**From:** Martyn White  
**Sent:** 11 December 2018 17:21  
**To:** Planning.Responses  
**Cc:** Amber Willard  
**Subject:** AW/275/18/HH

**AW/275/18/HH**

The application is seeking permission for a development of: first floor side extension, loft conversion with rear dormer, rear canopy, and extension to detached garage

Drawing Title:
PROPOSED PLANS & ELEVATIONS

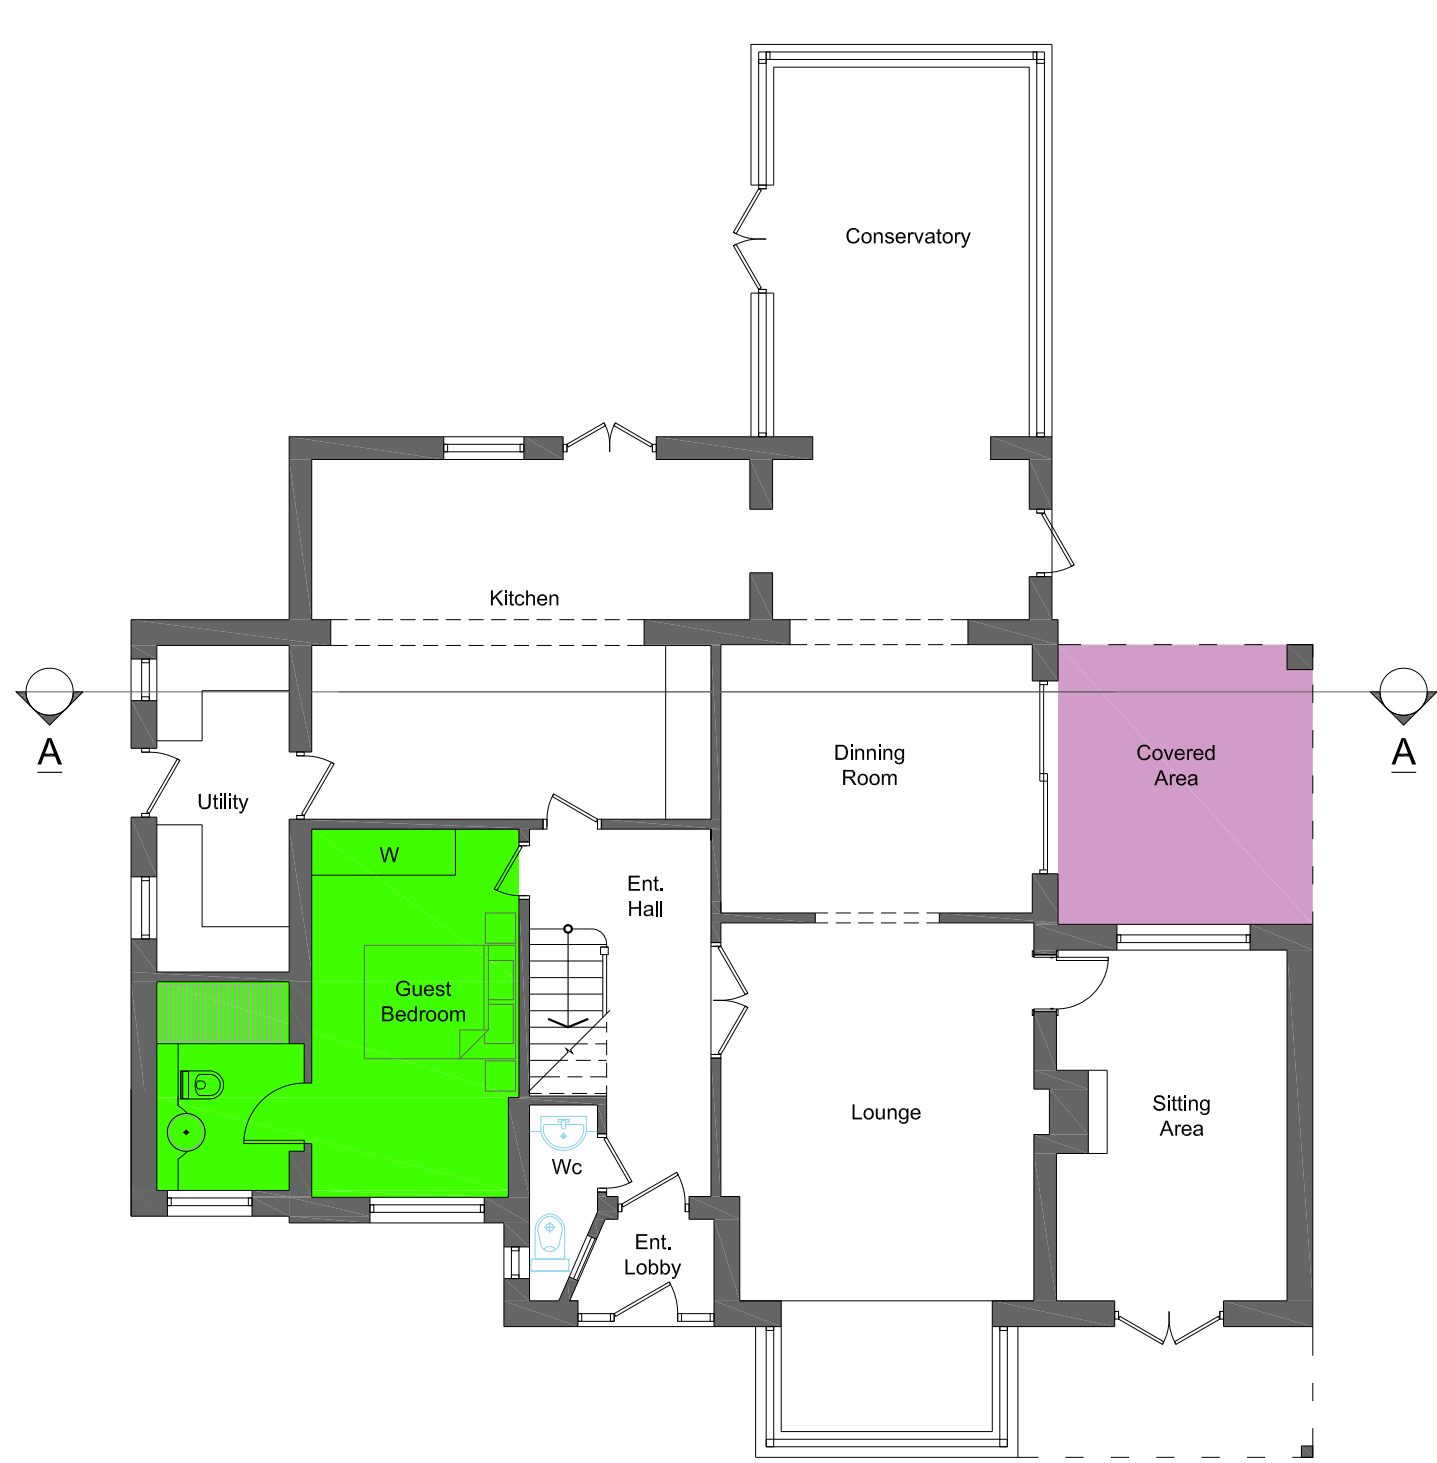
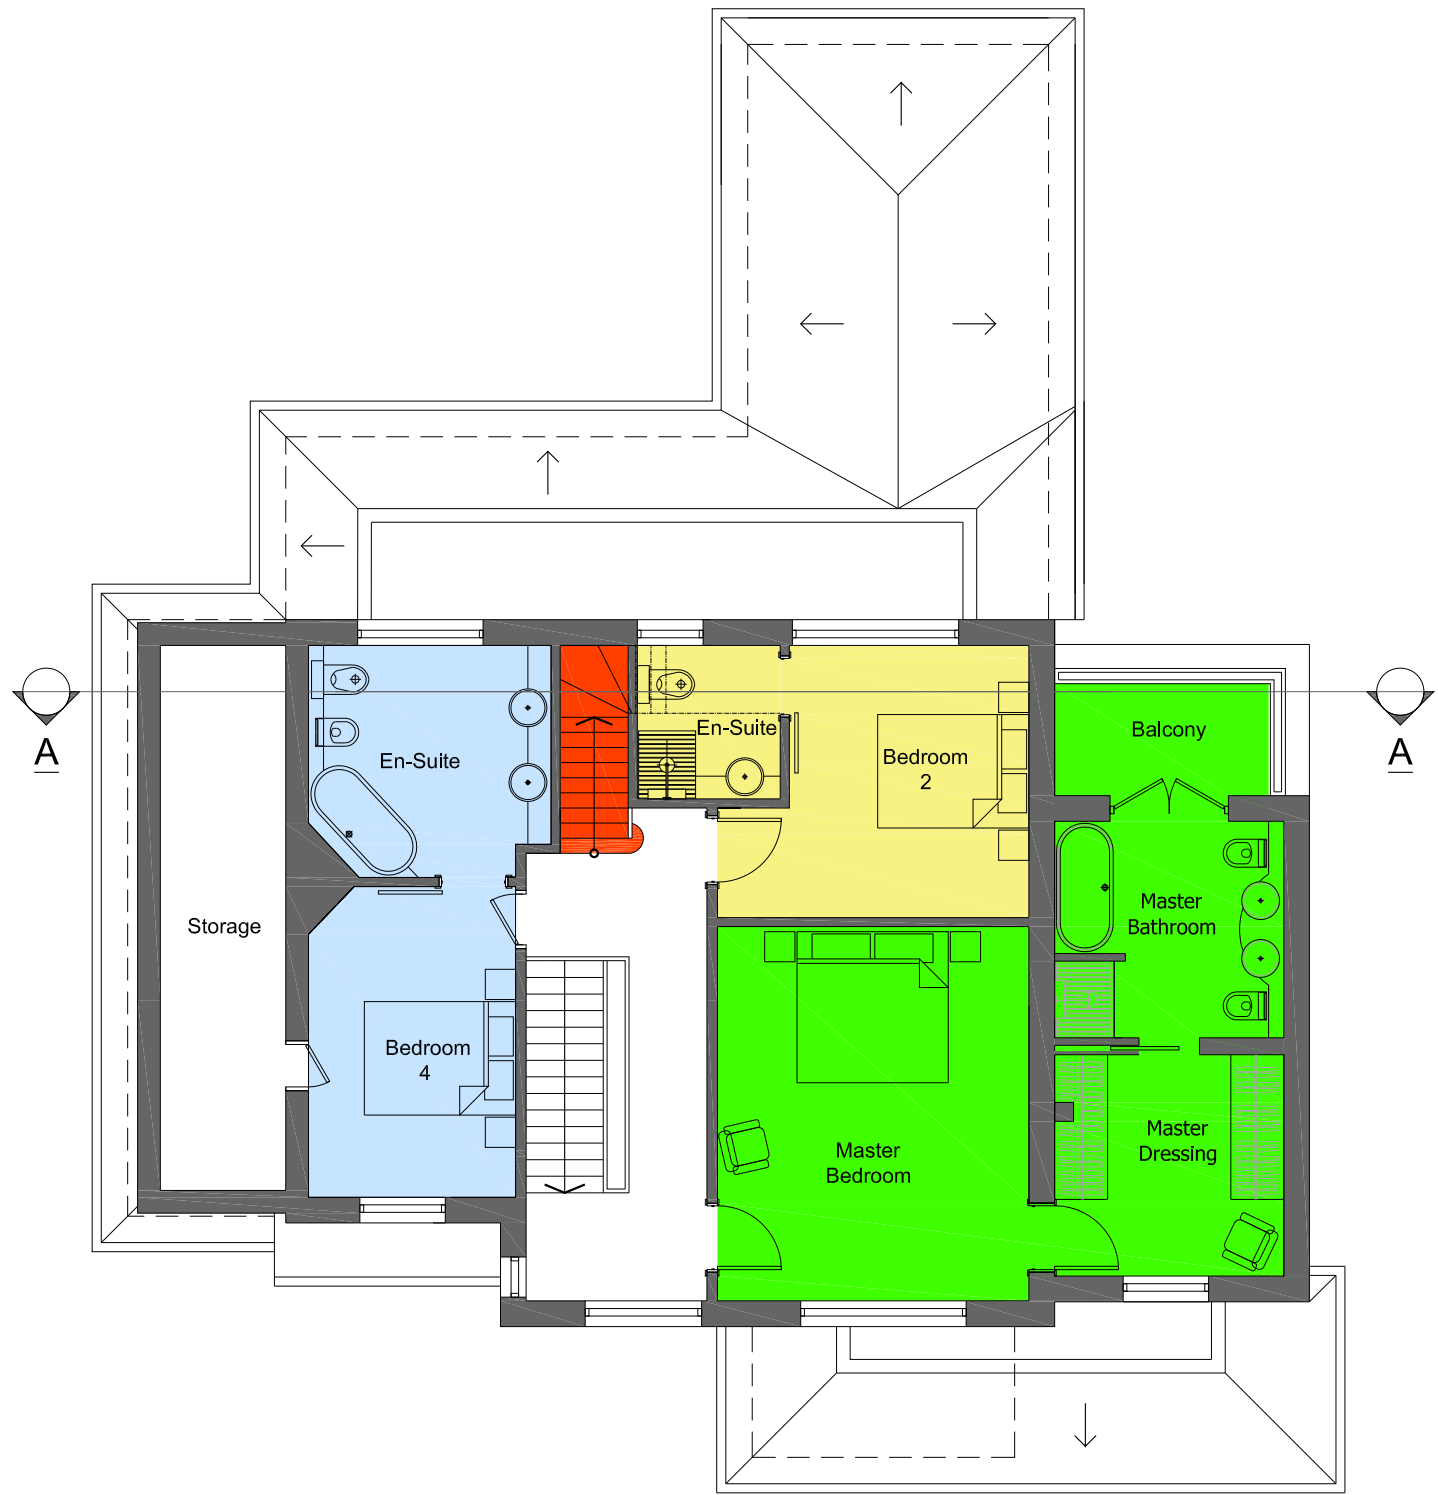
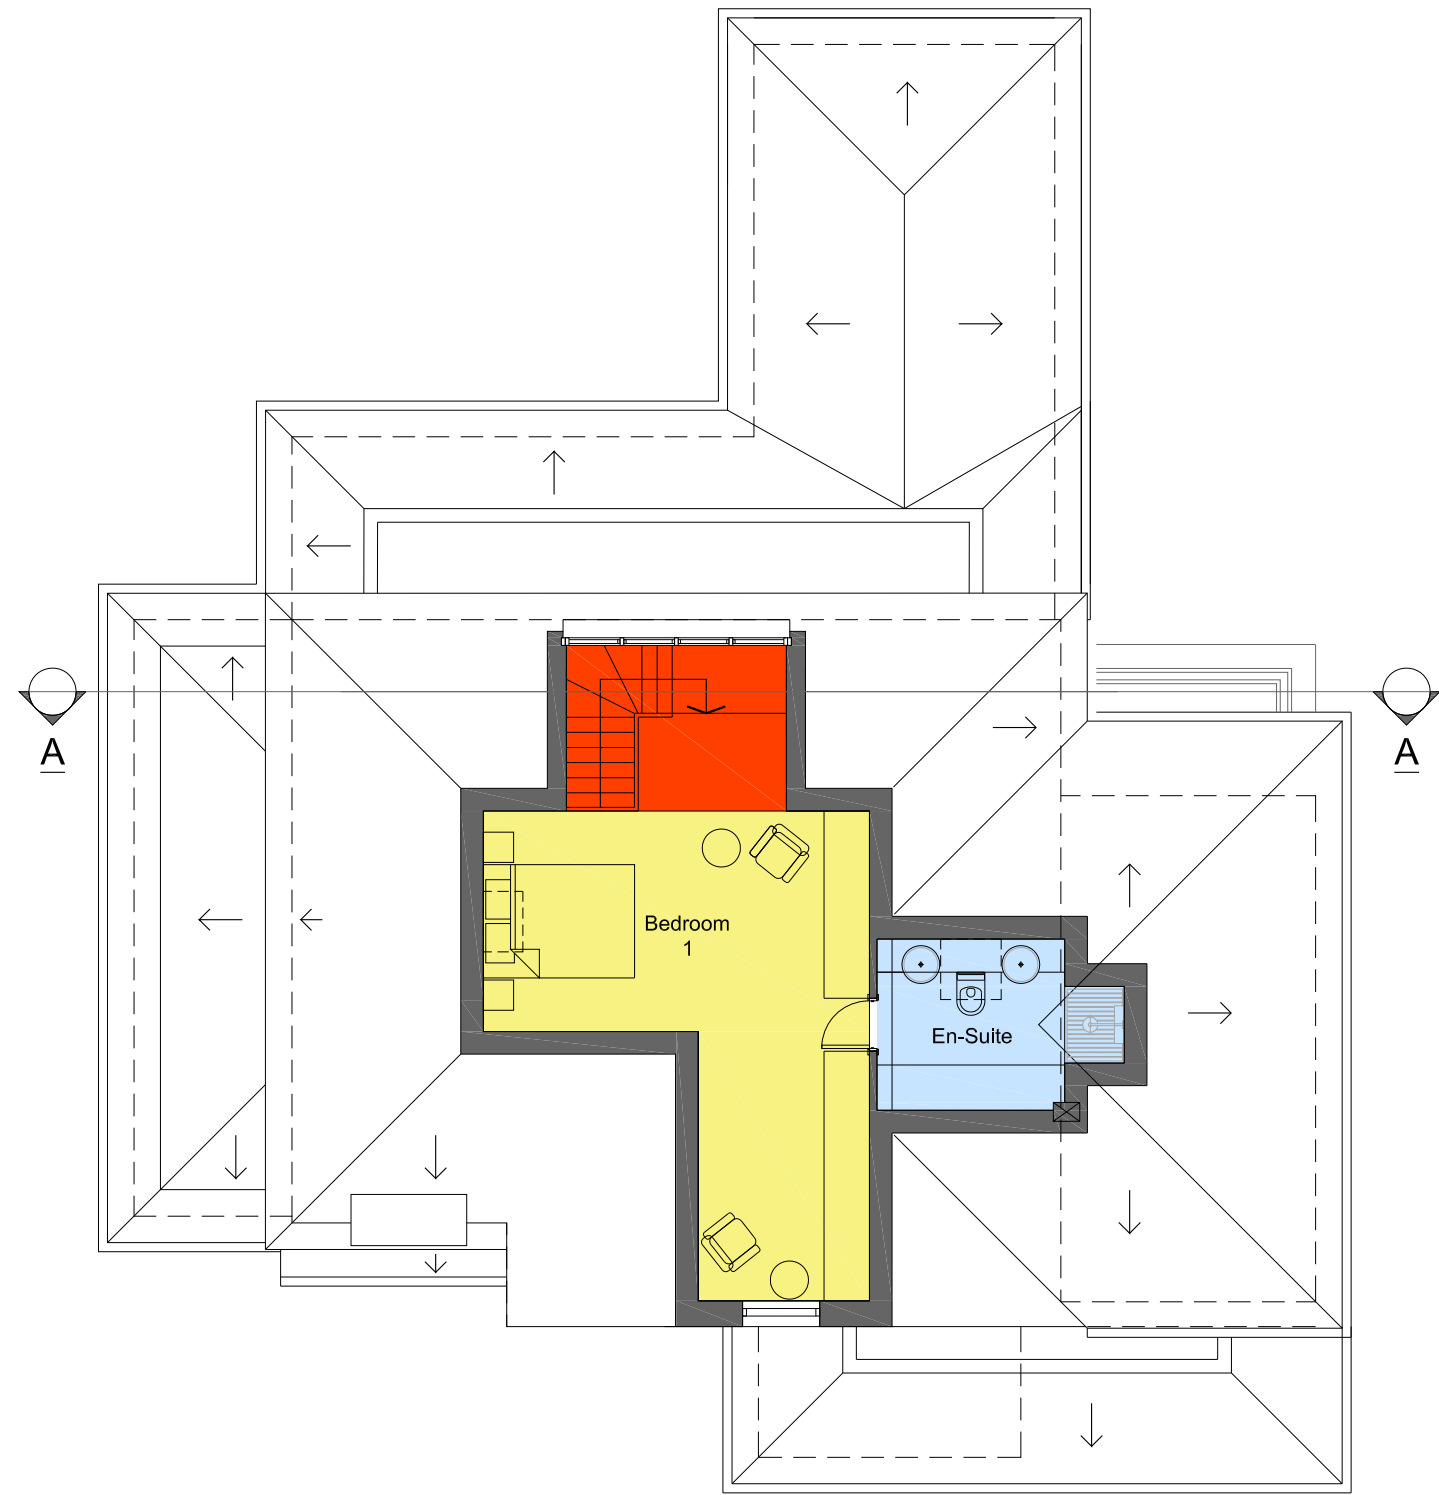
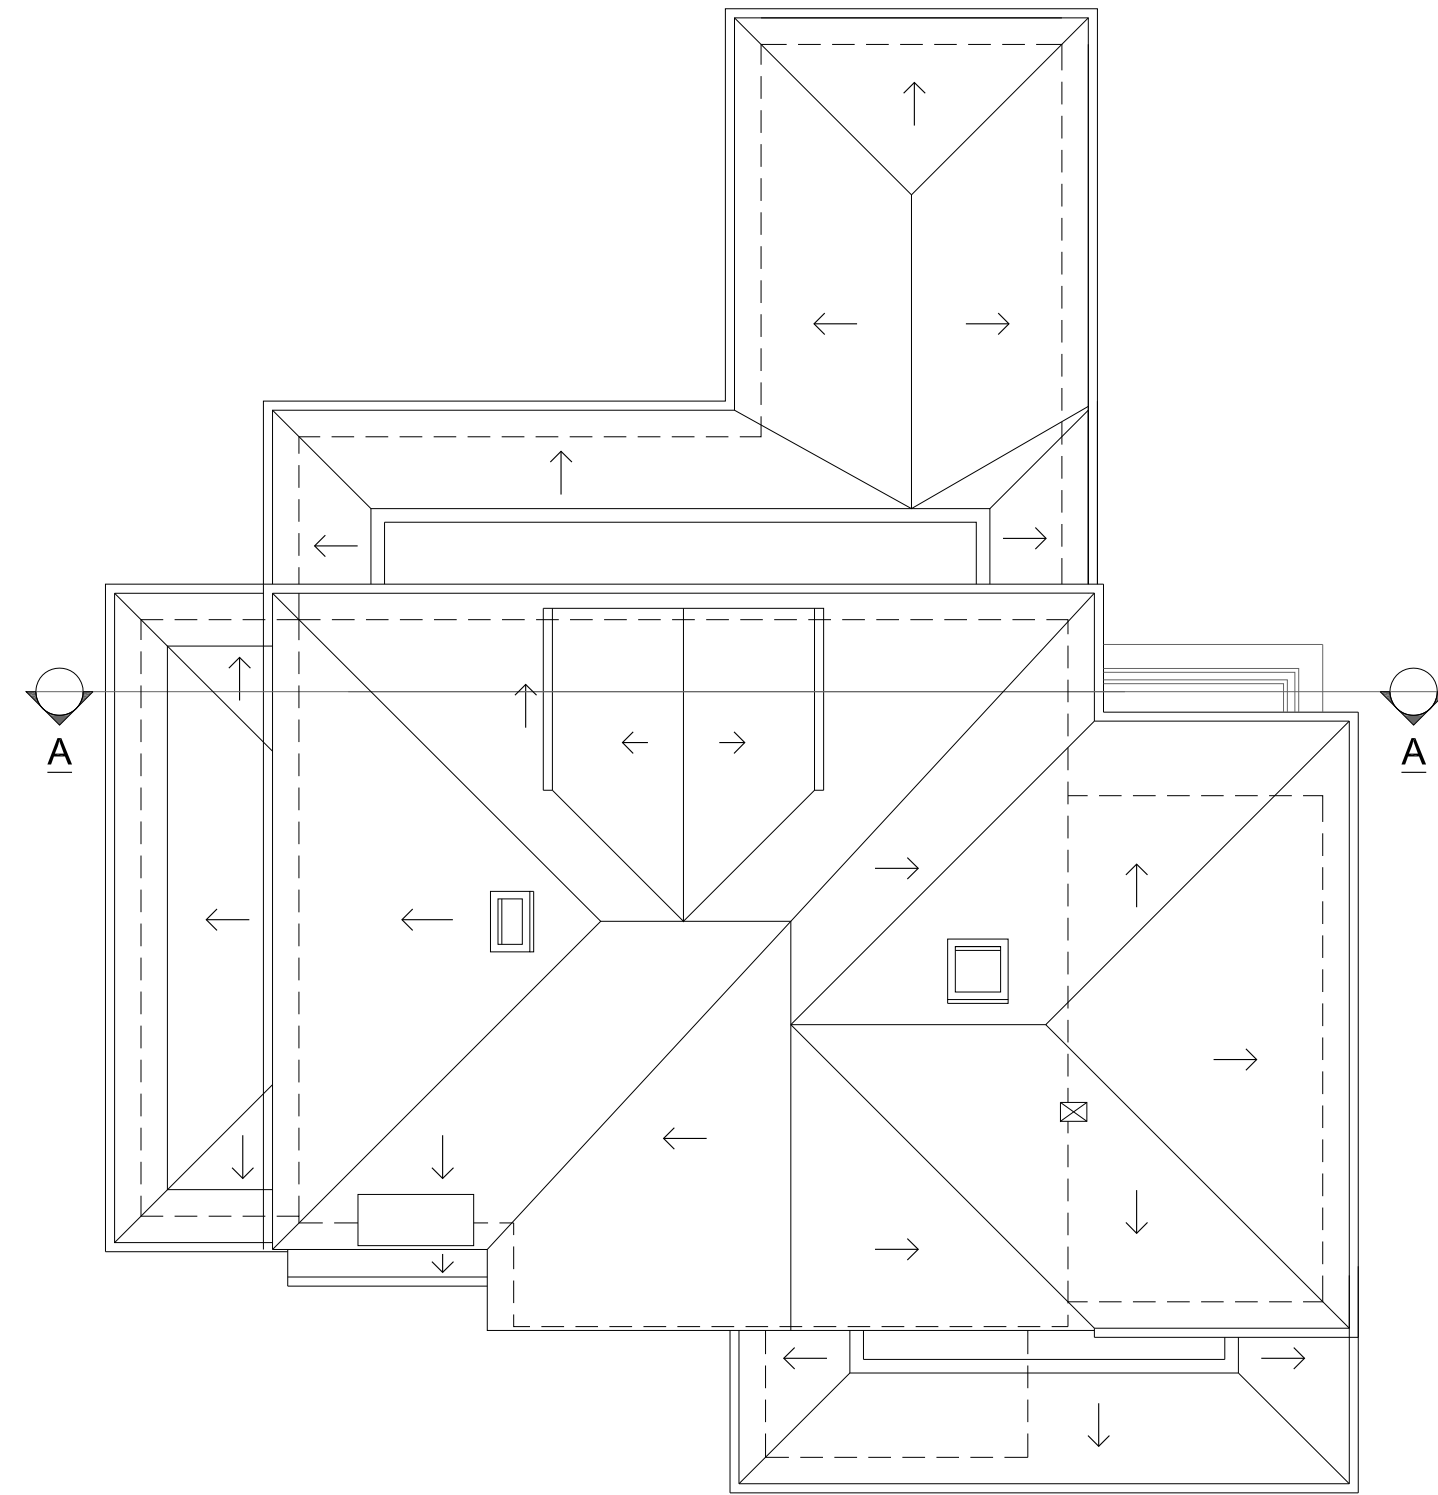
The application amounts to a substantial amount of work to the property with the side extension potentially having the greatest impact upon the character of the area, as it is visible from the public realm. Such an extension appears to be designed to reflect the character of the host dwelling, and subject to issues related to materials can be supported.

The rear dormer is substantial, occupying approximately ¼ of the proposed rear elevation. As a consequence, it appears to dominate the property. The size of the dormer is queried; does it need to be this size, or is there potential to reduce its size, and therefore its impact?

The success of the works will depend upon the quality of the material to be used. If minded to approve the application, materials should match existing. The rooflights should be of conservation standard.
